**Proposal:** Change of Use of an agricultural barn to a single dwelling-house (Use Class C3)

- 2.1. The current application seeks permission under Part 3 (Class Q) of the GPDO 2015 (as amended) for (a) the Change of use from agricultural building to residential dwelling (Class C3) and (b) building operations reasonably necessary to convert the said building to the said use. The current application relates to the modern steel-framed barn North of the Farmstead.

FIRST FLOOR STRUCTURE

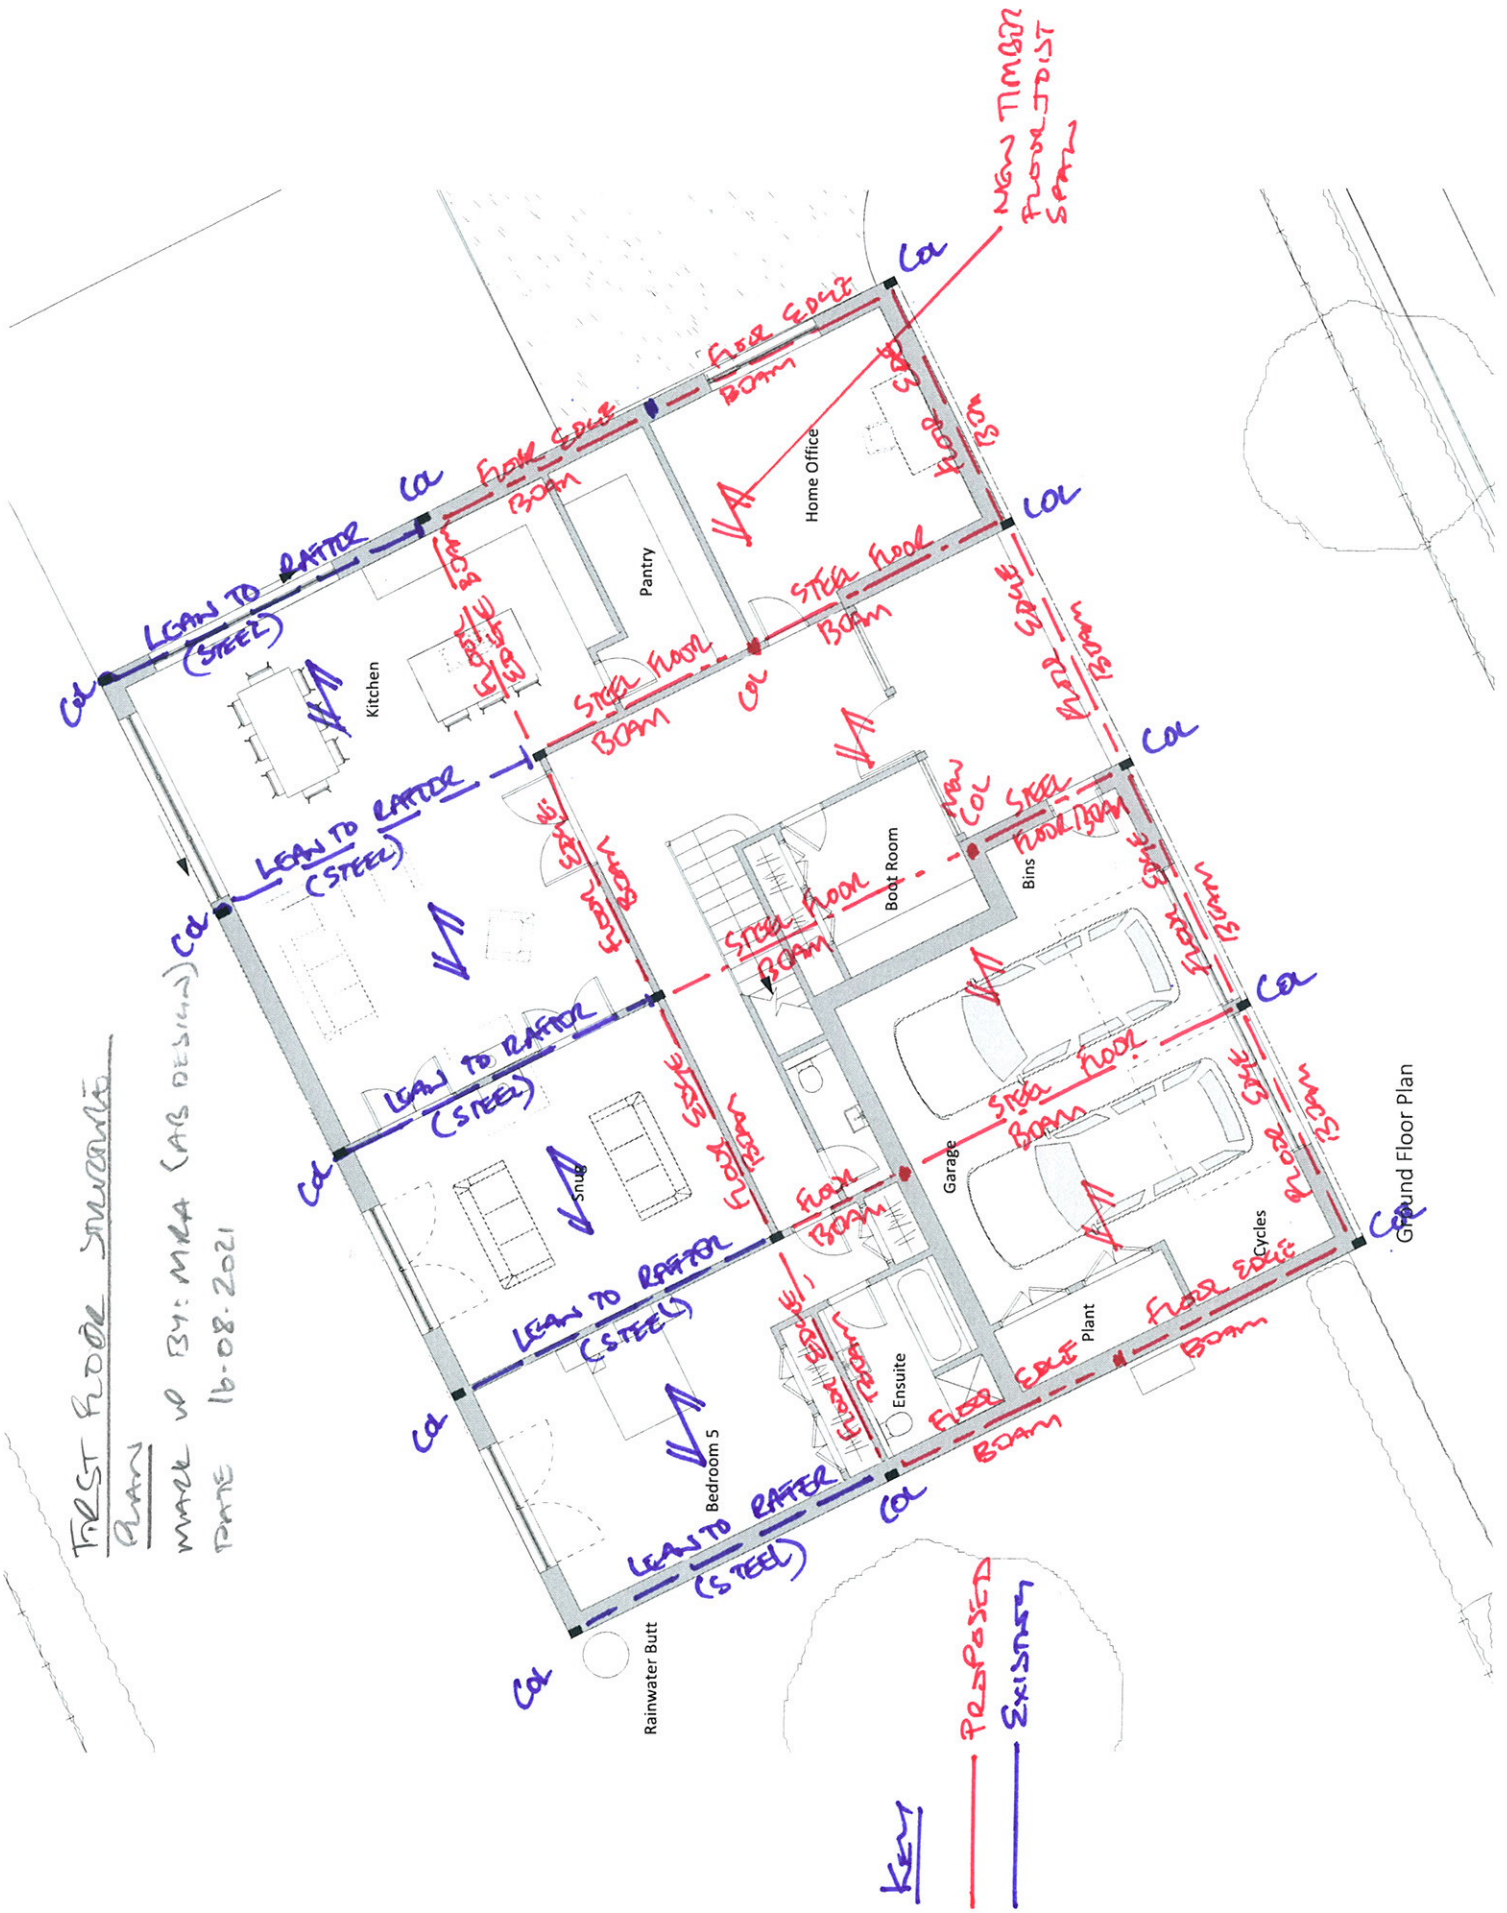
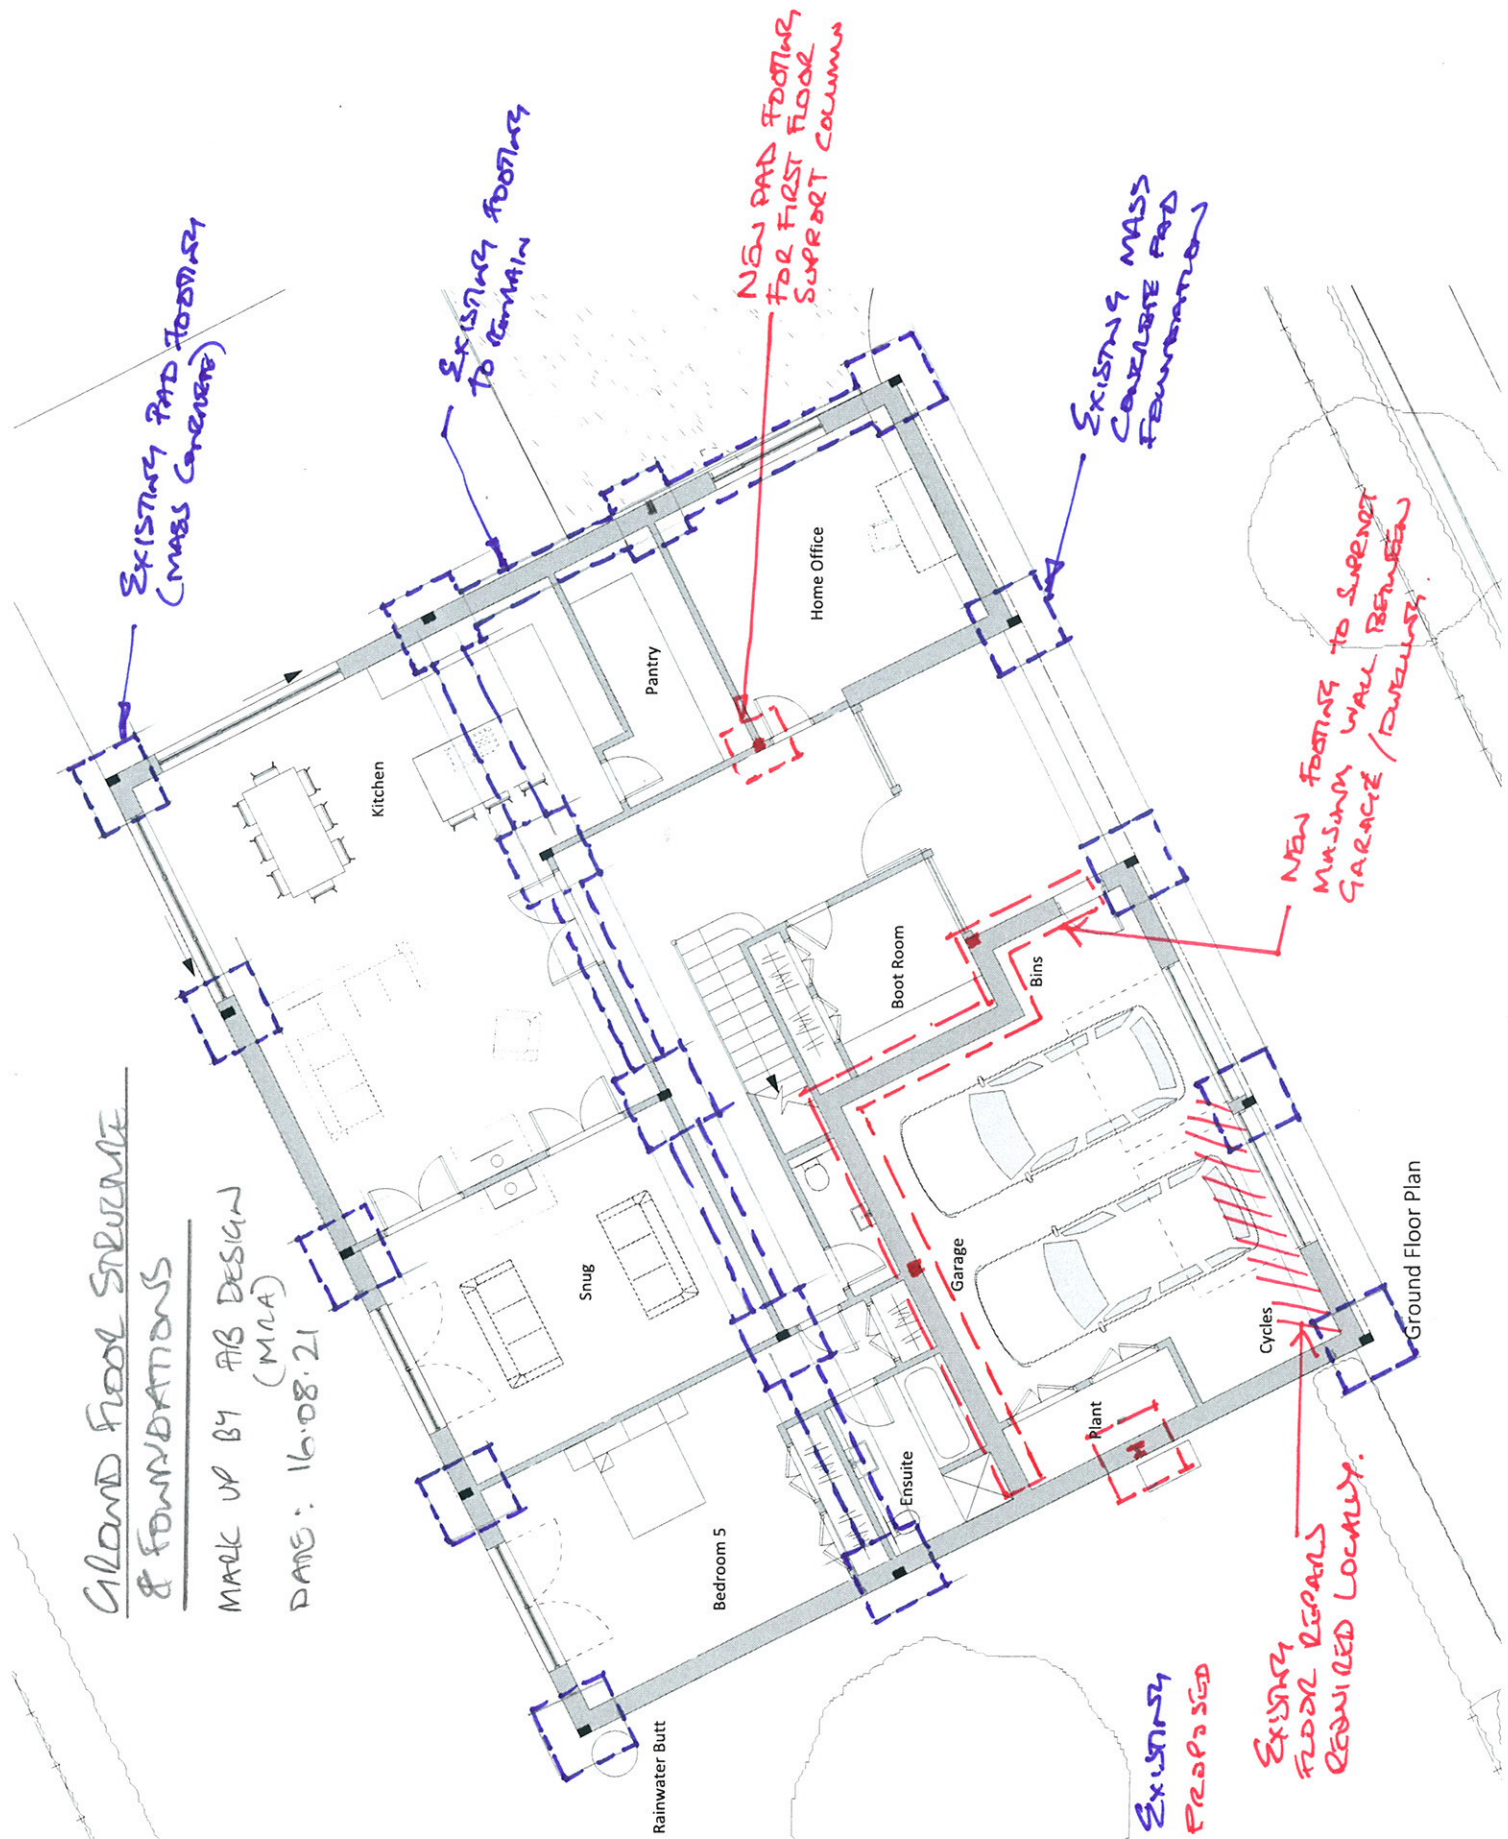
8.16 In the Council’s view, the works proposed are considerable. New pad footings are proposed in several places. There is a new upright/support proposed on the western elevation. All proposed walls are new and it would appear from the submitted drawings together with observation of the state of the existing building that a new roof is proposed.
